**DRAINAGE PLAN  
FOR  
WINROCK RESTAURANT SITE**

RE: DRAINAGE PLAN FOR TWO WINROCK RESTAURANT SITES (J190-D56) ENGINEER'S  
STAMP DATED 9/16/92.

**RE: WINROCK SHOPPING CENTER  
RESTAURANT SITE DRAINAGE PLAN RESUBMITTAL**

CITY OF ALBUQUERQUE PUBLIC WORKS DEPARTMENT ENGINEERING GROUP					
TITLE: DRAINAGE PLAN WINROCK RESTAURANT SITES					
APPROVALS	ENGINEER	DATE	APPROVALS	ENGINEER	DATE
D.R.C. Chair			Water		
Transportation			Waste Water		
Hydrology					
DRAWING NO.		MAP NO.		SHEET OF

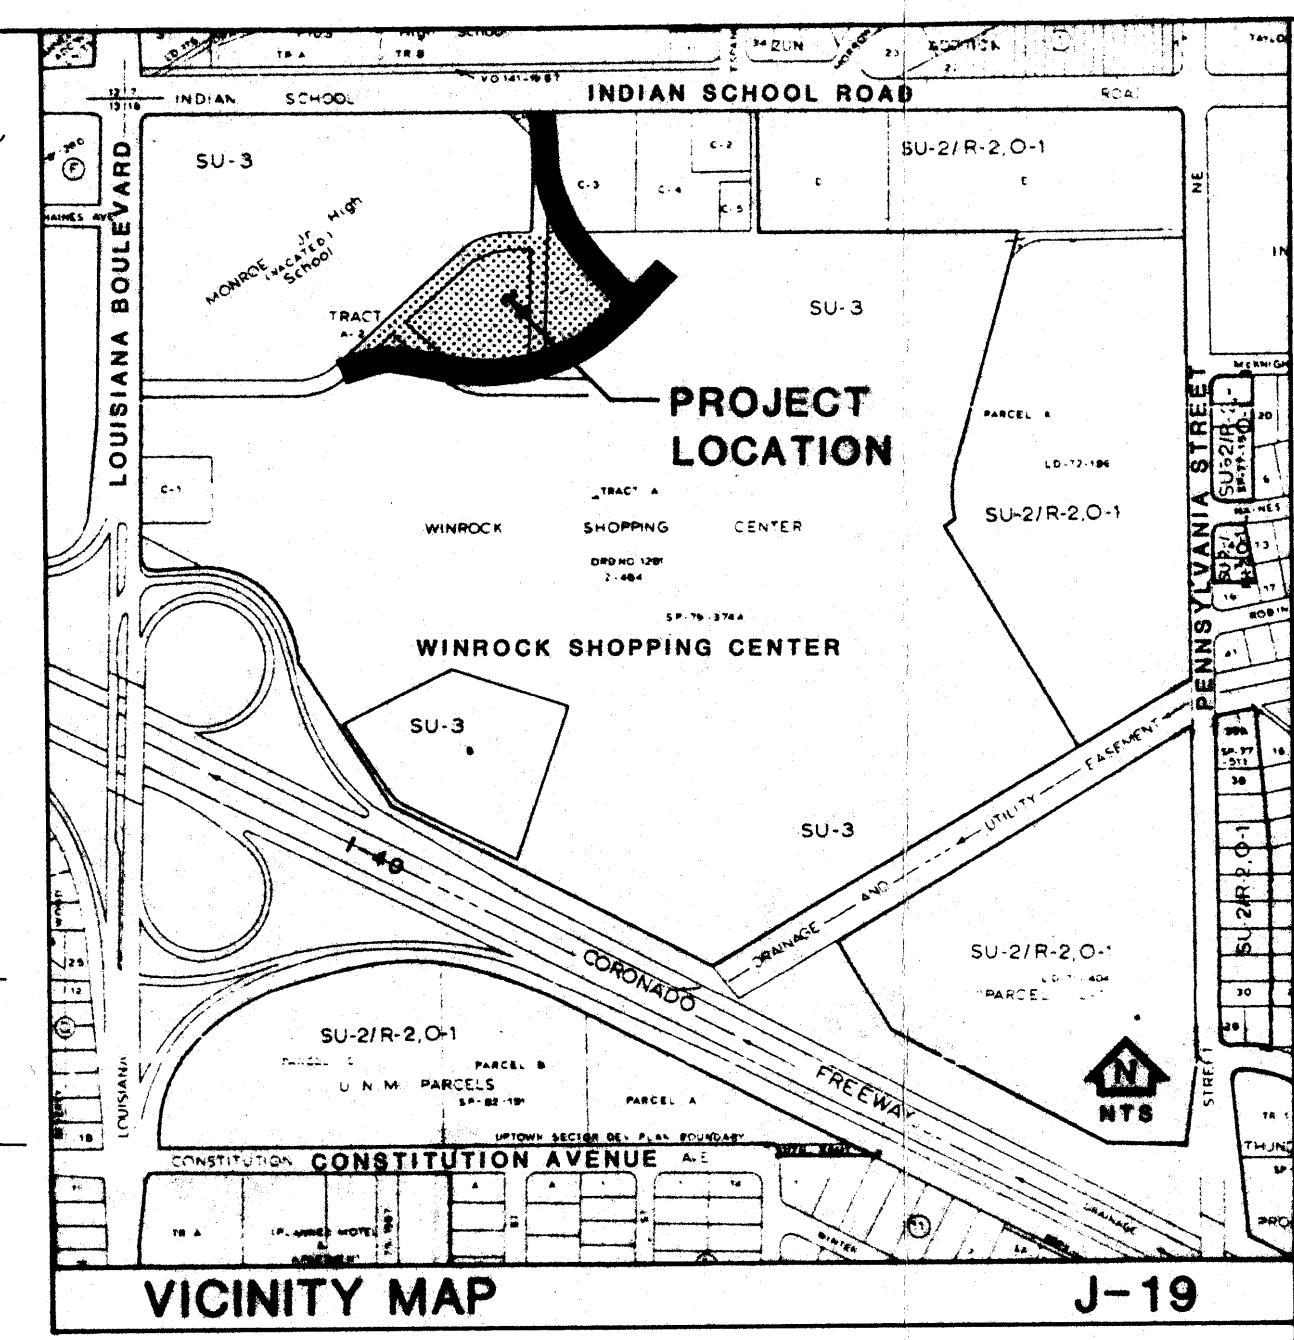
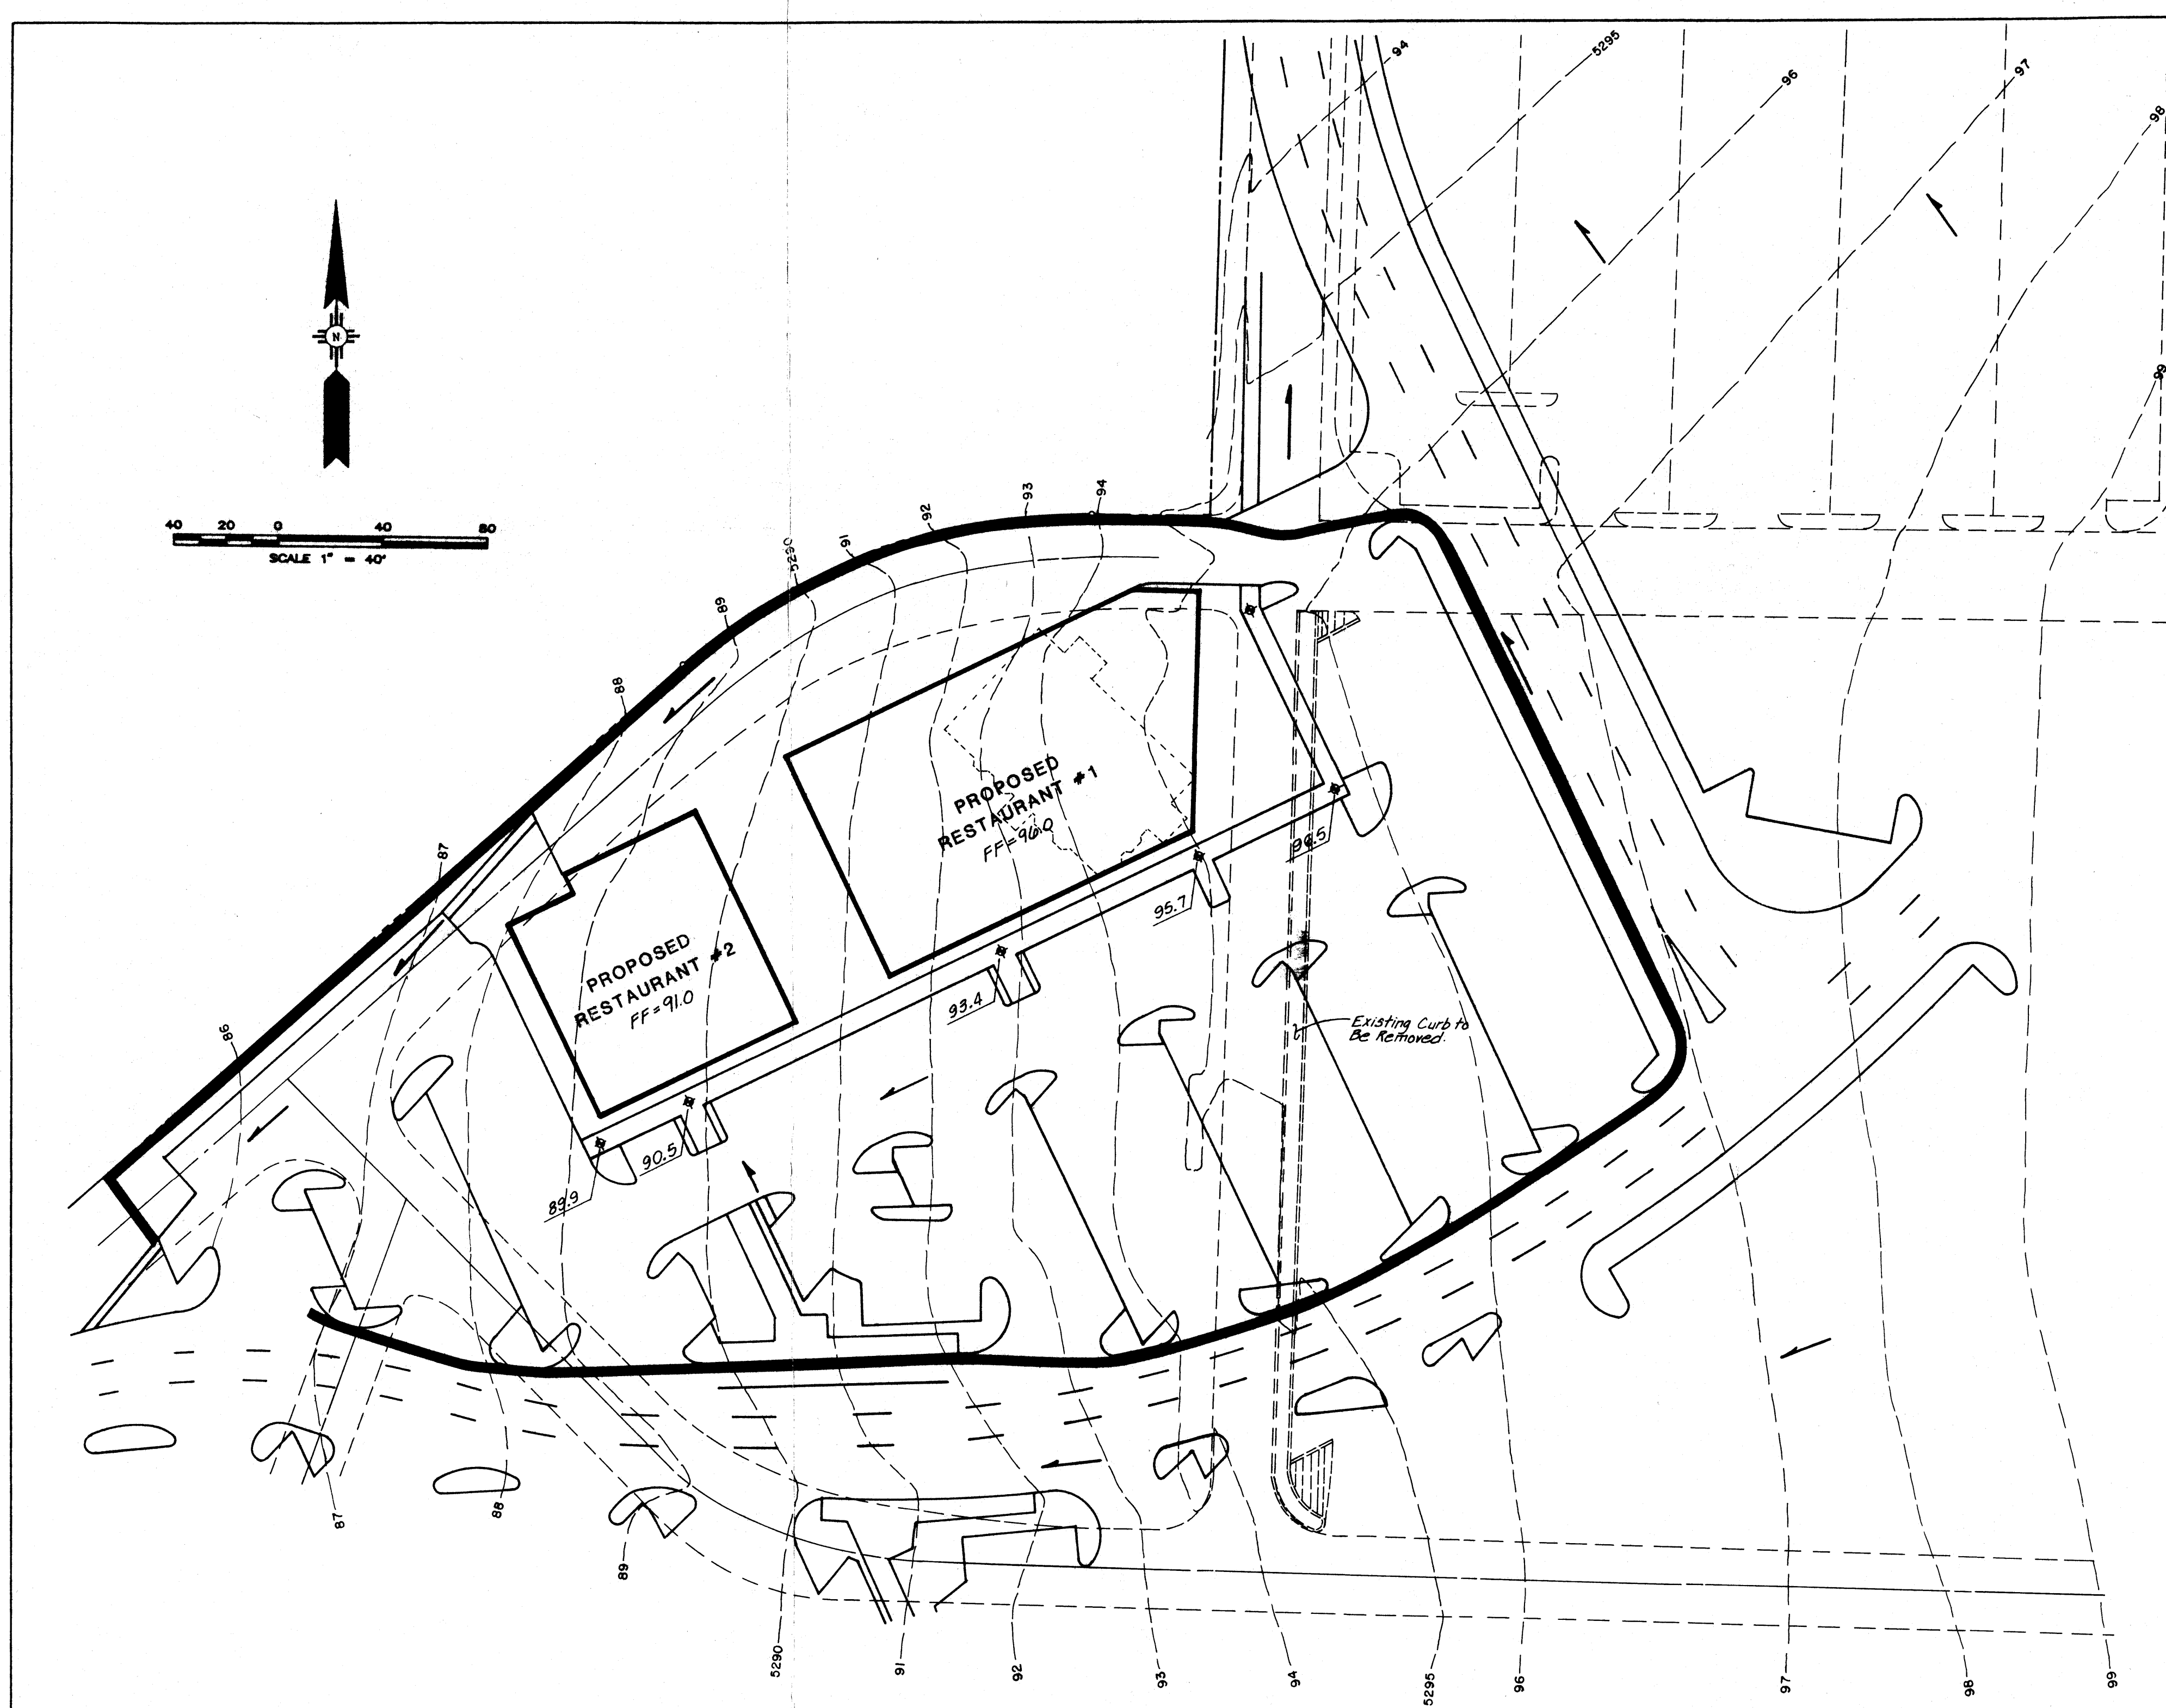
1. Will both restaurants be built under the same Building Permit?
2. Benchmarks - location, description and elevation of the:
  - A. Albuquerque Central Survey Vertical Datum used.
  - B. Temporary bench mark on-site permanently marked.
3. Flow rates - Calculations showing on-site undeveloped and developed flow rates. Flow rates will decrease with the required and landscaping.
4. Finish floor elevation must be to full mean sea level designation.
5. Location and direction of roof drains. If roof drain will be located within a landscaped area, then provisions must be provided for release of run-off onto the asphalt areas.

6. If the proposed restaurants are going to be built with separate Building Permit applications, then you may want to break up the drainage plan submittal into Phase I and Phase II.
7. I need more spot elevations around the asphalt area to show flow directions and required 1/2 % slopes.
